Our Case Number: ABP-309770-21

Re: Proposed development of up to 15 wind turbines with a tip height of up to 175 metres and laying of approximately 26km of underground electricity cabling to facilitate the connection to the national grid, and all associated site development works
Townlands of Camagh, Carlanstown, Coole, Clonrobert, Clonsura, Doon, Monkstown, Mullagh, Newcastle and other townlands, Co. Westmeath

Case reference: PA25M.309770

Submitters: Joe Clarke/ Oonagh Clarke

Figure 13-11: Proposed road to T15 in relation to newly recorded potential archaeological monument.

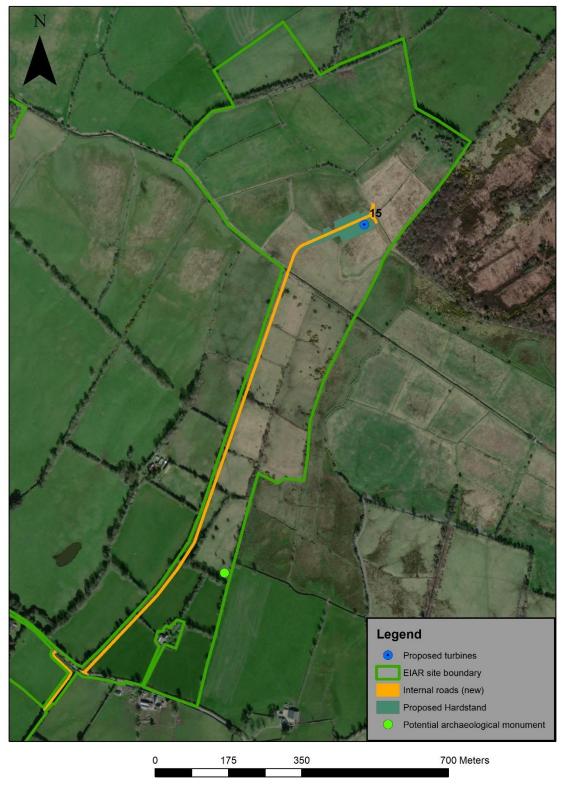
There are no mitigations referred to in regards to archaeology. This is an archeologically rich area. Proposed Turbine no.2 is situated right beside a crannog. What will be done to protect this crannog? There is an archaeological ridge situated right beside Turbine no 15. No mitigations mentioned to protect this either. If this was a domestic build a full archaeological dig would be insisted upon prior to any building work, at considerable expense. Why not here?

This archaeological and cultural heritage chapter was prepared by Tobar Archaeological Services. It presents the results of an archaeological and cultural heritage impact assessment for the Proposed Development.

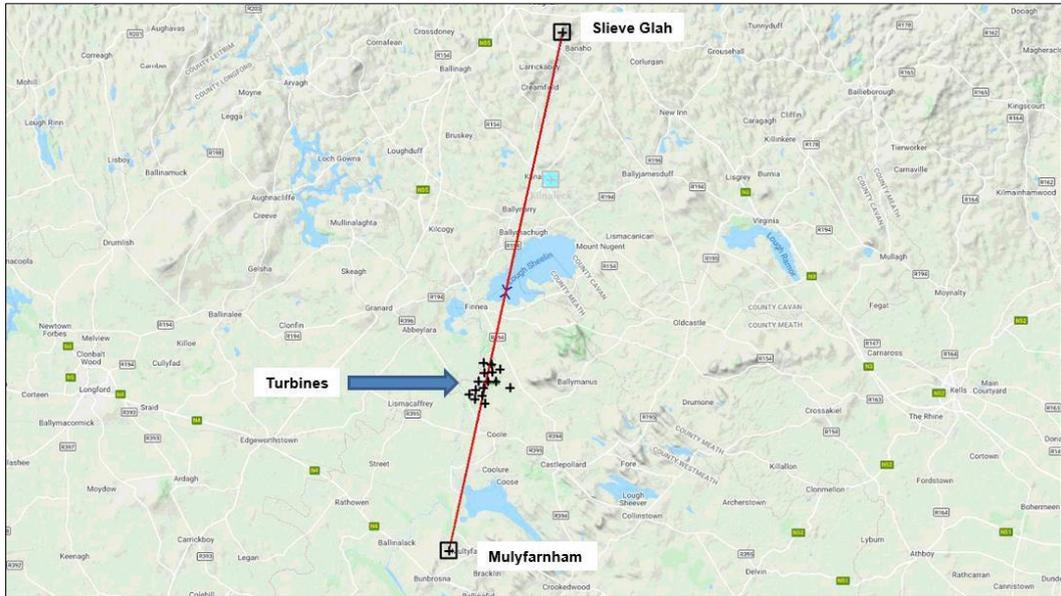
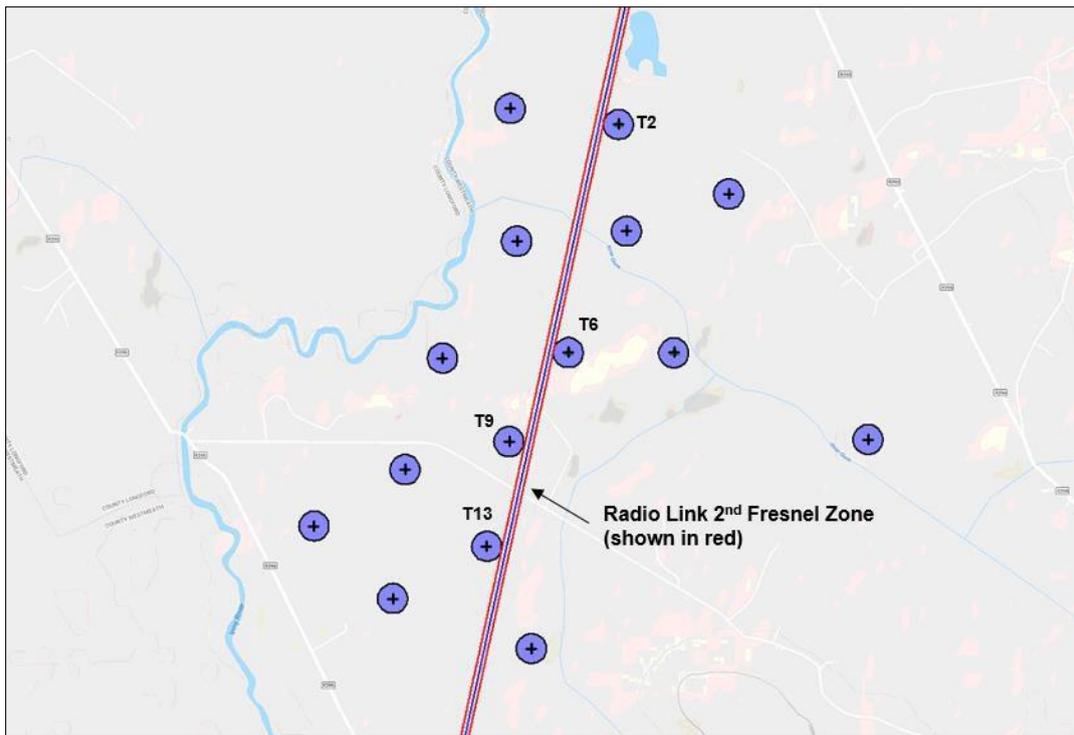
- 16) In fig. 3.2 it appears that turbines 2, 6, 9 and 13 are in the path of the buffer zone for Three Ireland. Three Ireland has the best mobile phone connection in this area. It is not good, but is the only viable one locally. This now is to be destroyed by the turbines.
